REQUEST

Current Zoning: N1-A (Neighborhood 1-A)
Proposed Zoning: B-1 (CD) (Neighborhood Business, Conditional)

Approximately 3.99 acres located at the intersection of Rhyne Road and Moores Chapel Road.

The petition proposes to develop a vacant property in northwest Charlotte with up to 10,000 square feet of uses permitted in the B-1 zoning district including 16 fuel pumps and a fast food restaurant with drive-through.

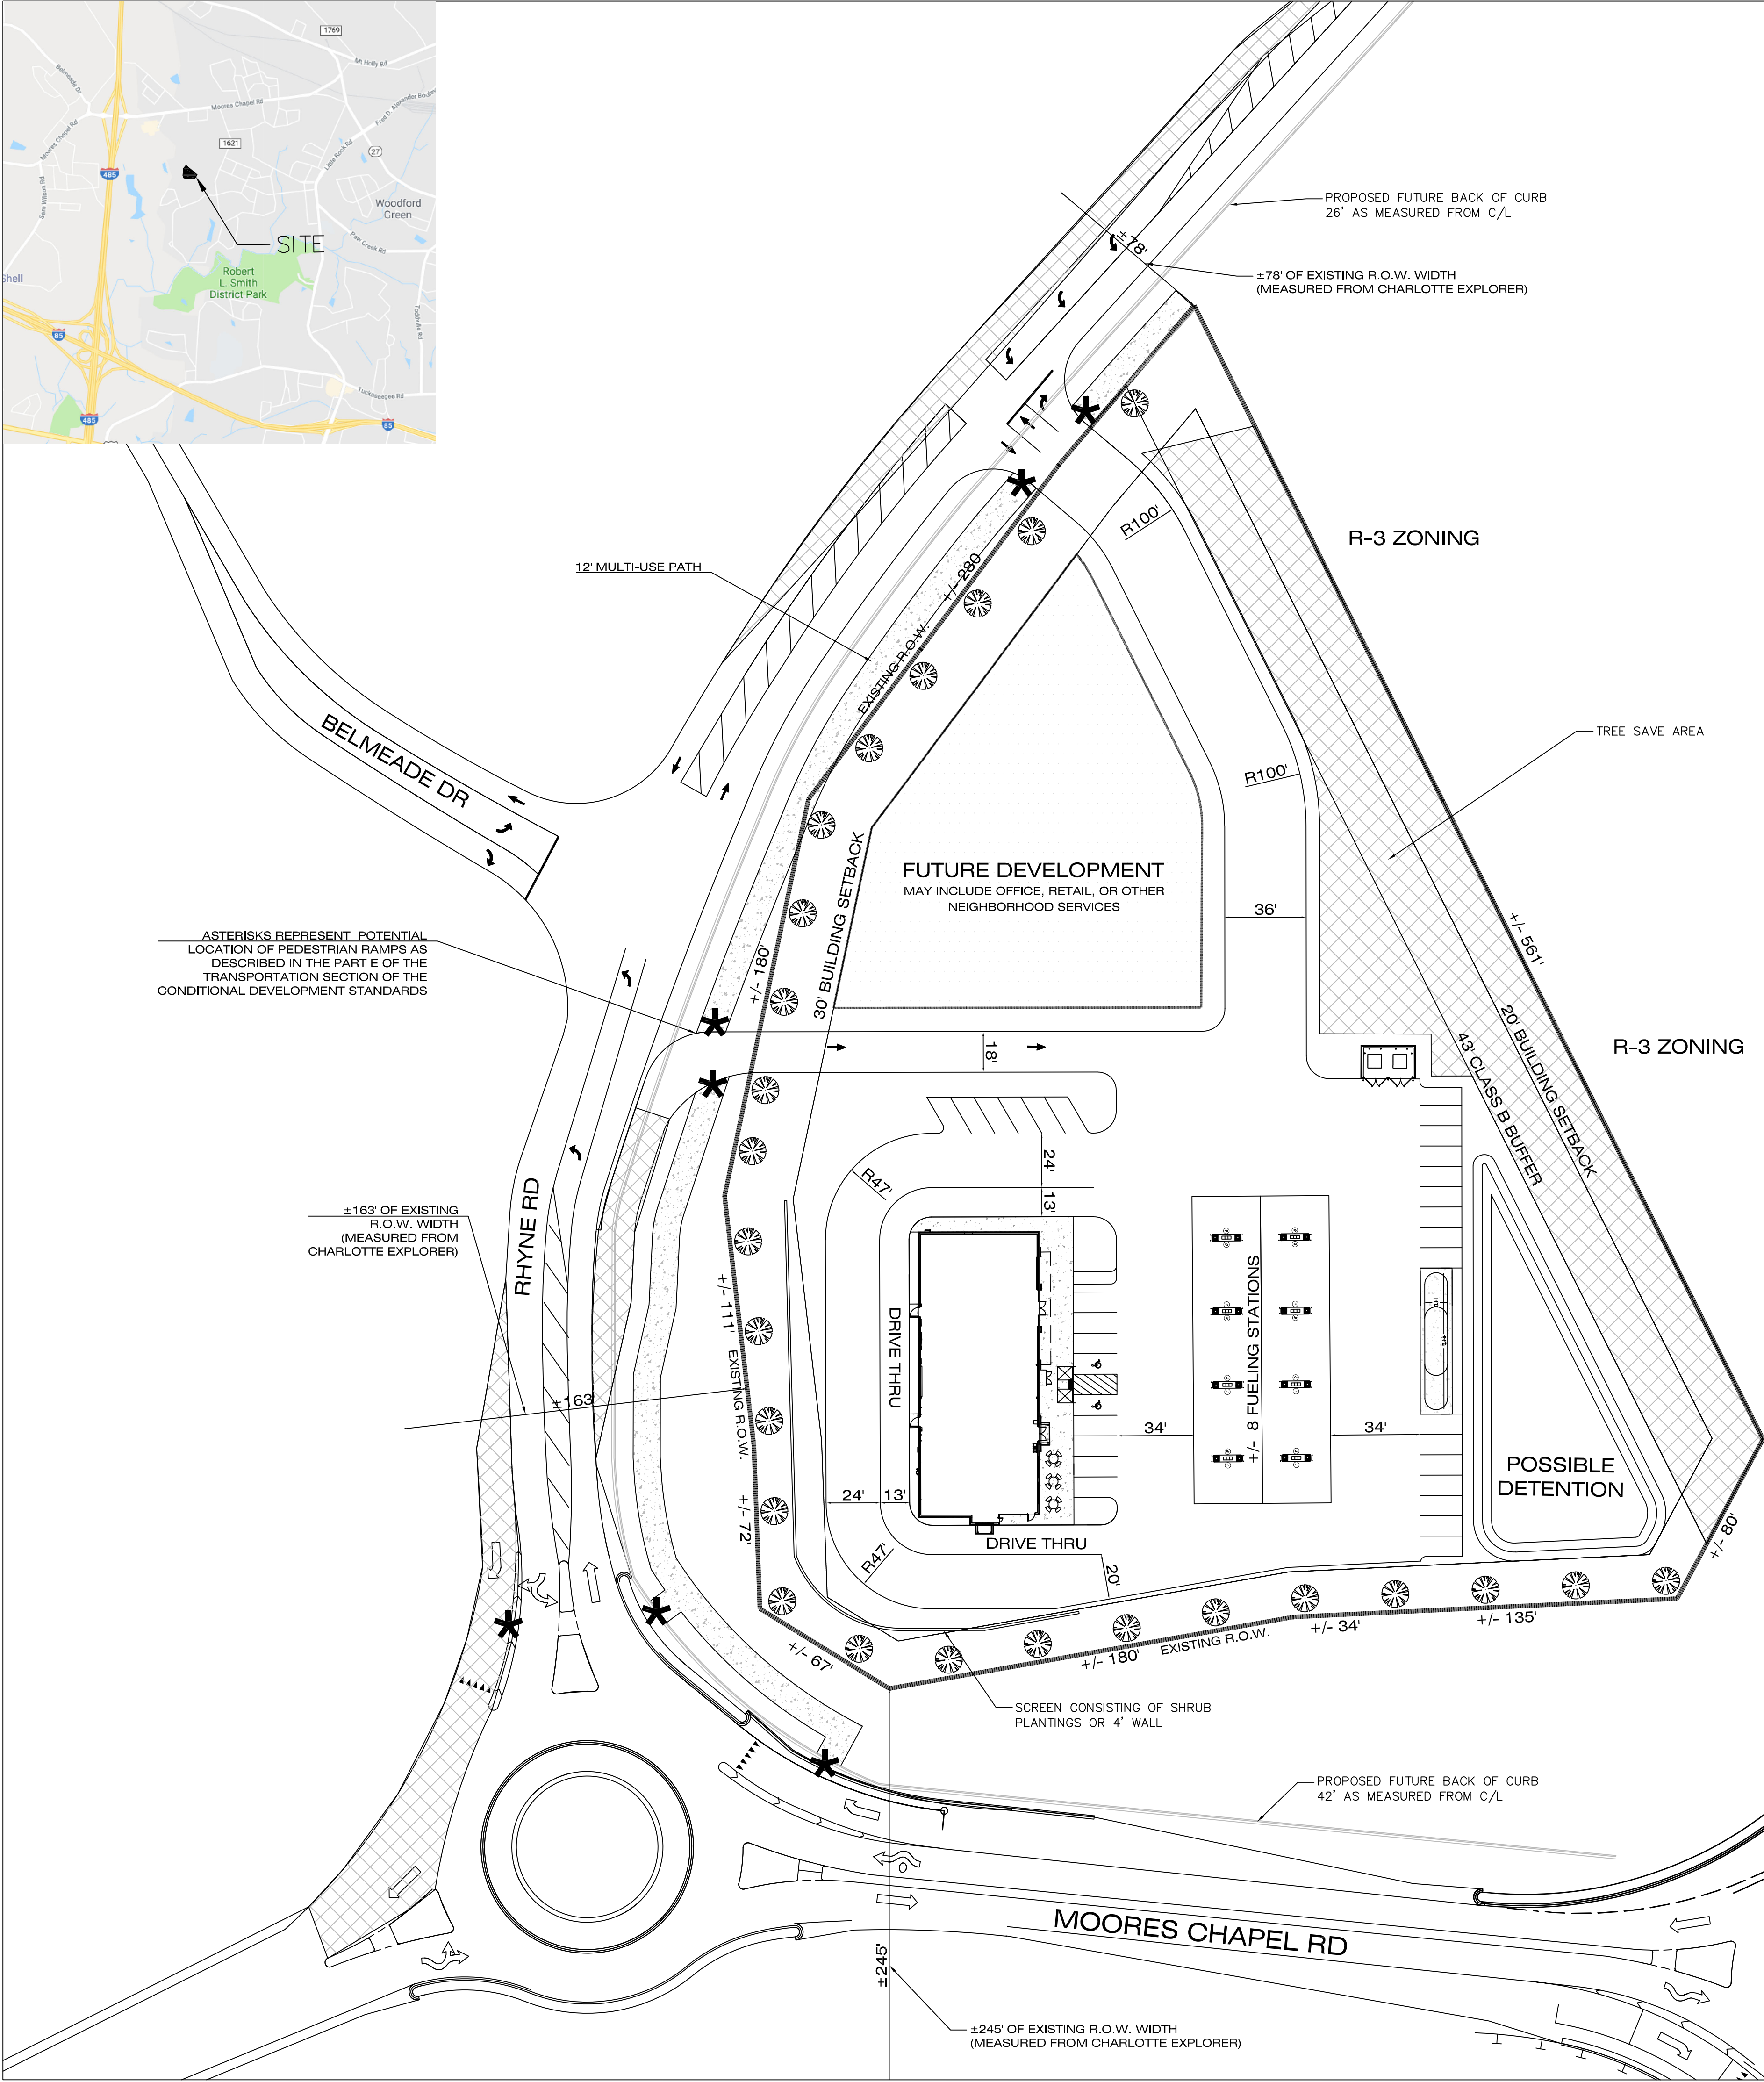
1. ~~Revise site plan and conditional note(s) to provide 12-foot multi-use path and 8-foot planting strip for the remainder of the Moores Chapel Road frontage. Sidewalk facilities are required per City ordinance for all public street frontages.~~ Revise the ramp locations and conditional note Transportation Note E to include the additional ramps that will be required. Provide SUE located 2 feet behind sidewalk if located outside of the ROW. Add conditional note to coordinate Control of Access Break with NCDOT for proposed multi-use path along Moores Chapel Road. **ADDRESSED**

2. ~~Label and dimension streetscape along all public road frontages (12-foot multi-use path and 8-foot planting strip). Revise ramp locations as shown above and update conditional note to incorporate additional ramps. Provide SUE located 2 feet behind sidewalk if located outside of the ROW. Add conditional note to coordinate Control of Access Break with NCDOT for proposed multi-use path along Moores Chapel Road.~~ **ADDRESSED**

3. ~~Label, dimension, and commit to curb and gutter and multi-use path in conditional notes.~~ **ADDRESSED**
4. ~~Add a conditional note specifying that all transportation improvements will be approved and constructed before the site's first building certificate of occupancy is issued as needed. The petitioner may phase transportation improvements if said improvements and phasing are explicitly described in site plan notes.~~ **ADDRESSED**

6. ~~Remove "Convert the southbound right turn lane to a free flow right" as its mentioned twice. Then add the following to the first sentence for the Moores Chapel at I-485 SB Off-Ramp intersection~~

~~"Convert the southbound right turn lane to a free-flow right with channelization island." (See CDOT Memo 04-09-24)~~ **ADDRESSED**

- ~~7. Rhyne Rd At Belmeade—remove note regarding construction of an eastbound left turn lane on Belmeade with 150' of storage plus taper as it's already been constructed.~~ **ADDRESSED**

- ~~8. Remove the first sentence of Transportation note b. Connections between buildings and the public sidewalk are required by ordinance.~~ **ADDRESSED**
- ~~9. Revise Streetscape and Landscaping Note a to commit to screening the drive-through to UDO standards.~~ **ADDRESSED**
-
